From: [REDACTED]
Sent: 01 August 2018 13:57
To: [REDACTED]
Cc: [REDACTED]
Subject: RE: RE: #4857 Planning Consultation on: A/36/18/OUT Land off Arundel Road Angmering BN16 4ET

Application No: A/36/18/OUT

Site: Land off Arundel Road Angmering BN16 4ET

Proposal: Outline planning application with some matters reserved for the erection of up to 200 dwellings with access, public open space, landscaping and sustainable drainage system (SuDS) with vehicular access point from Arundel Road, one full-sized adult football pitch and the demolition of industrial units and one residential dwelling. Departure from the Development Plan.

Figure 7.1 – Accident Location

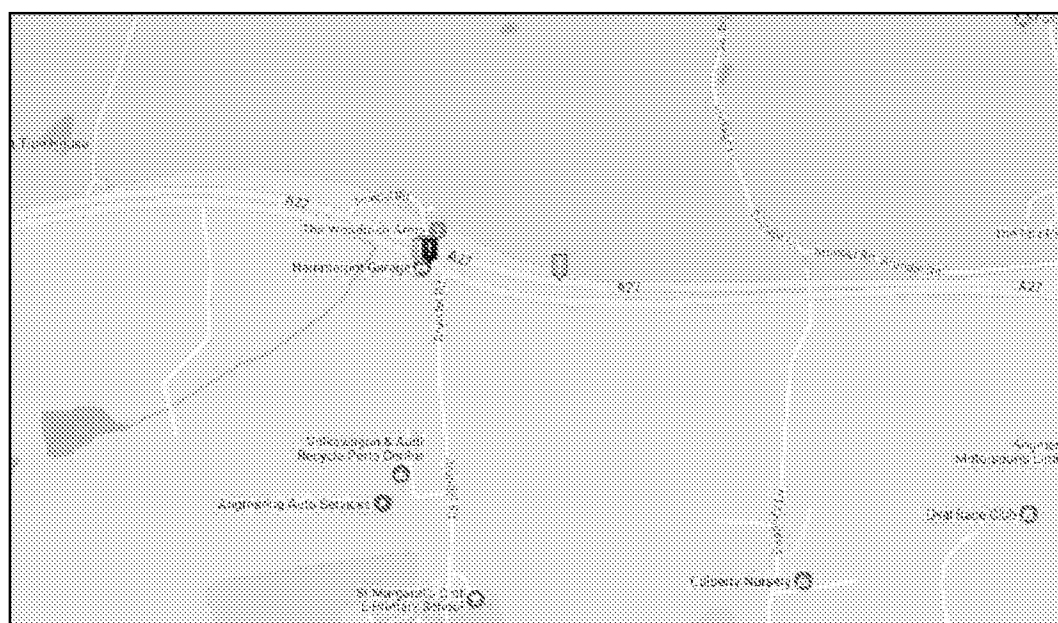
- Please provide full details of the accidents at the A27 U-turn facility at Poling Corner and at the A27 / Arundel Road junction as the updated TA only includes a summary from Crashmap.

- Paragraph 5.2.21 states that *"the existing infrastructure will facilitate safe and direct pedestrian linkages between the site and local destinations"*. However, para 7.1.36 identifies that there has been a fatal accident at this junction involving a pedestrian and para 7.1.38 identifies that *"some new warning signage could be provided at this location to alert drivers to the potential for pedestrians to be walking in the vicinity to improve safety, along with the provision of dropped kerbs and tactile paving at the crossing points"*. We are concerned that NMU's have not been properly considered with appropriate mitigation identified and in this respect we recommend use of the Design Manual for Roads and

Figure 7 - Committed Development (A/82/12) - 138 Units
AM Peak Period (0745 - 0845)

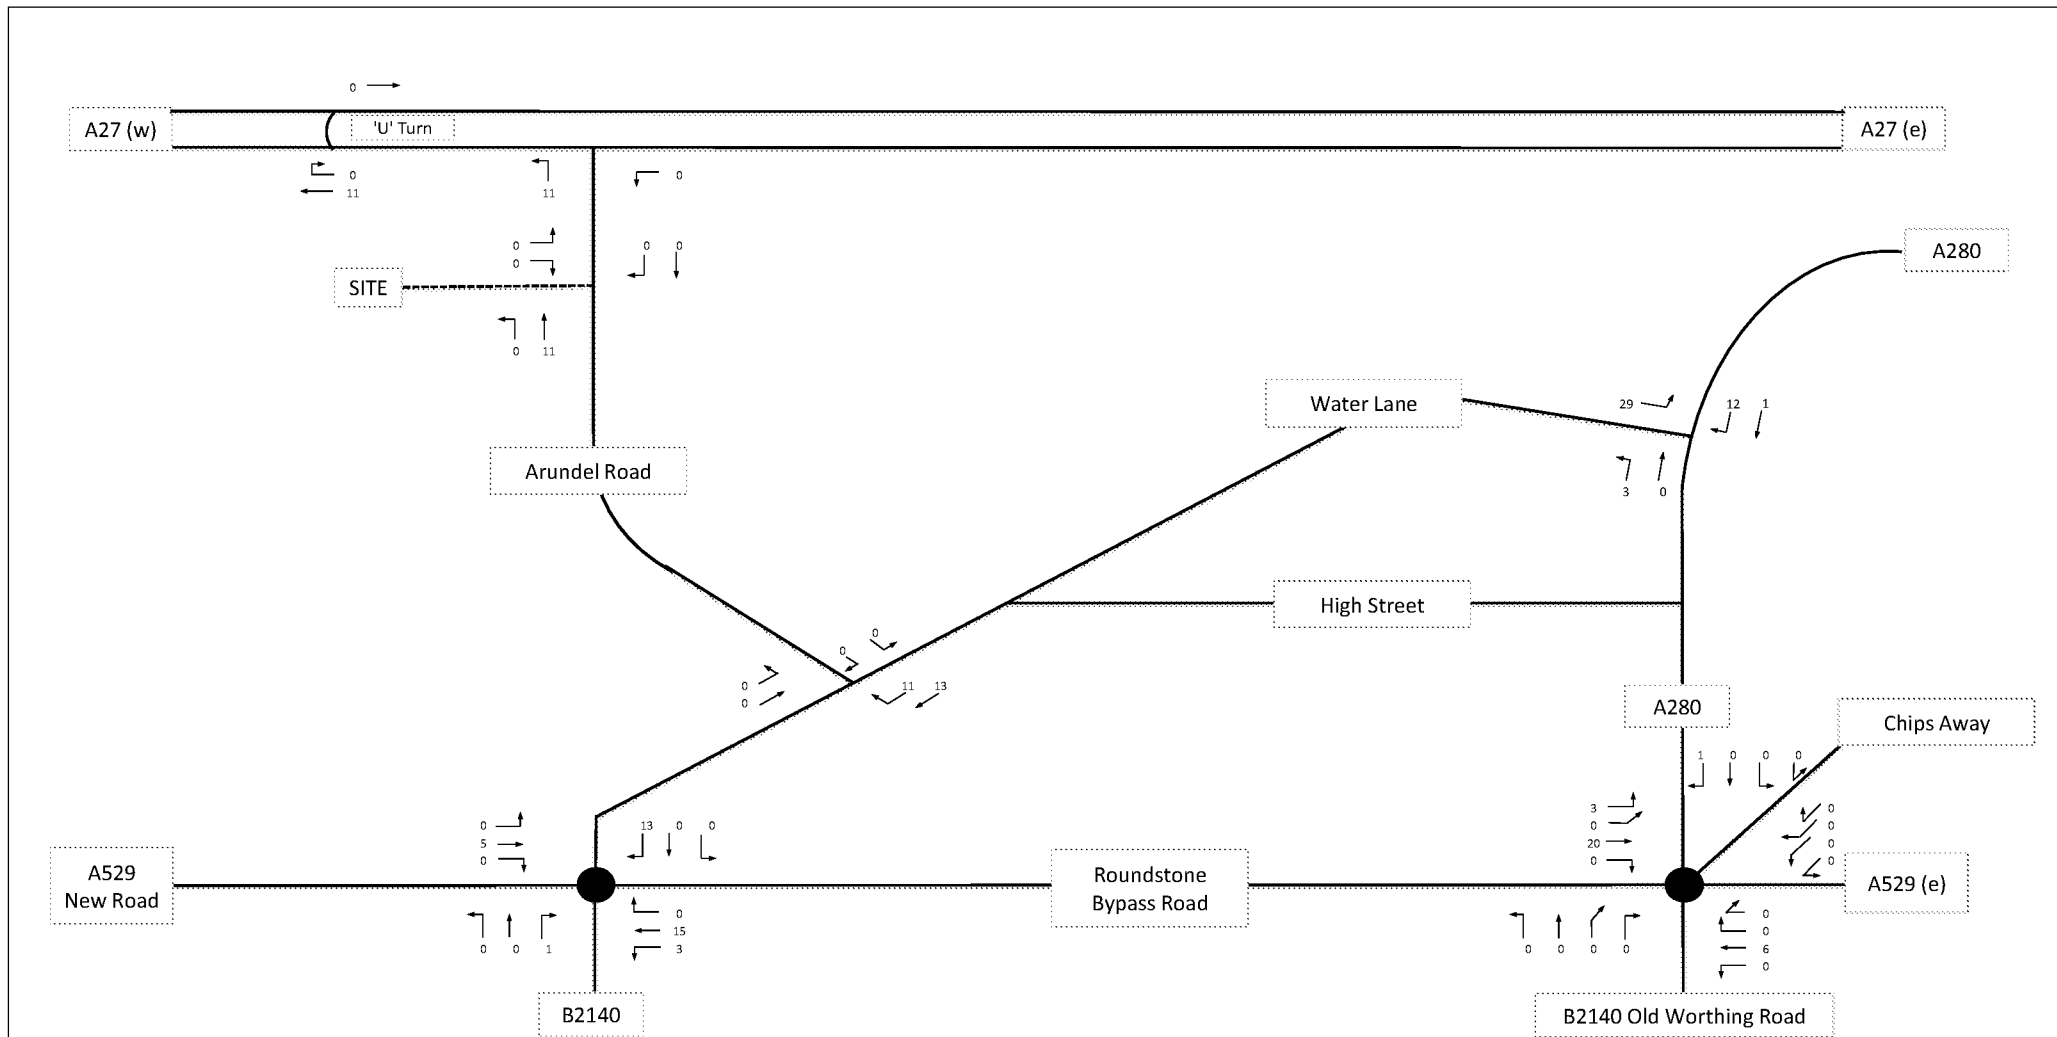
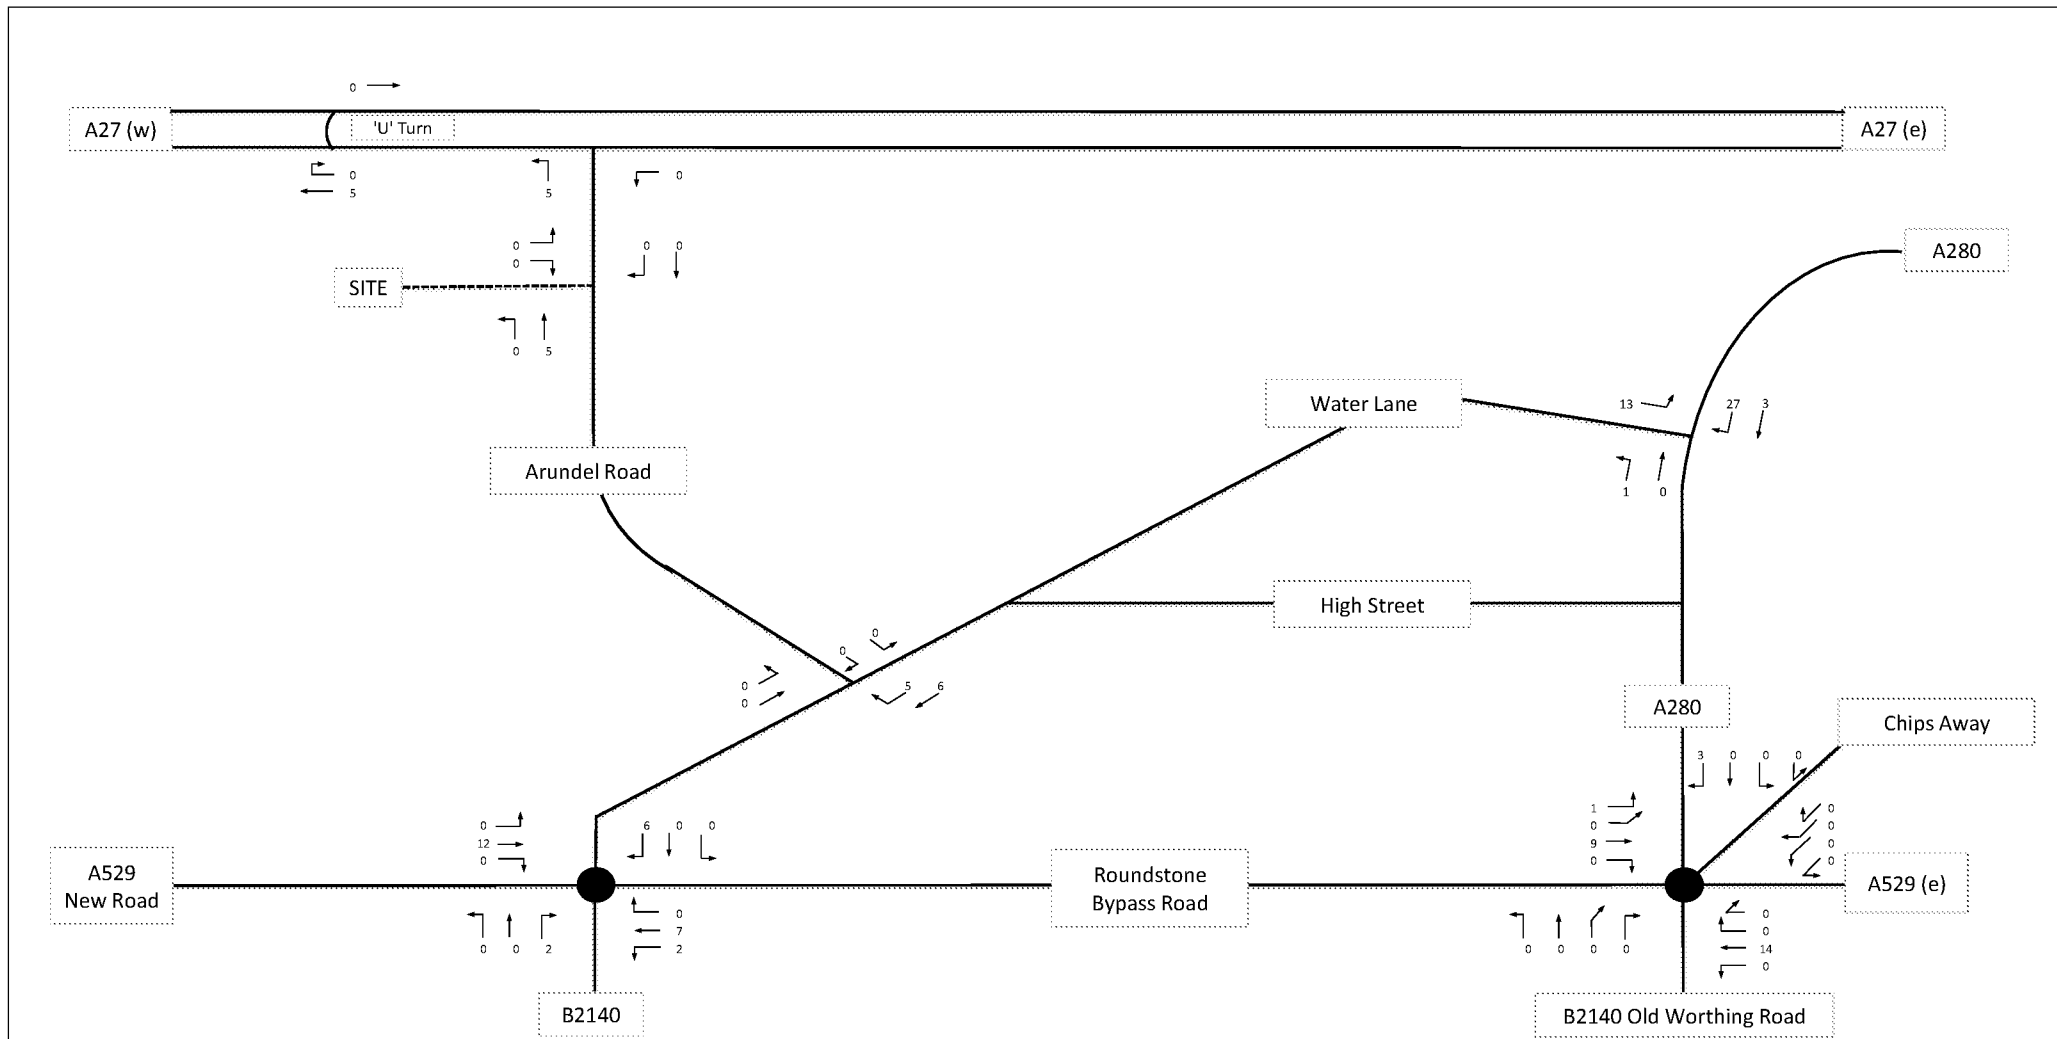
- The trip distribution is based on application A/82/12 (Land east of Roundstone Lane), which is located on the southeast side of Angmering near the A280. As such, we do not agree that the trip distribution would be the same as the proposed development is situated to the northwest of Angmering near the A27, and therefore we anticipate some traffic would use the A27 U-turn facility at Poling Corner. However, we note the survey results show that no queues were recorded at the right turn facility here and therefore any additional trips at the junction are unlikely to have a material impact on its operation. Accordingly, we are not requesting any further information in relation to your proposed distribution.
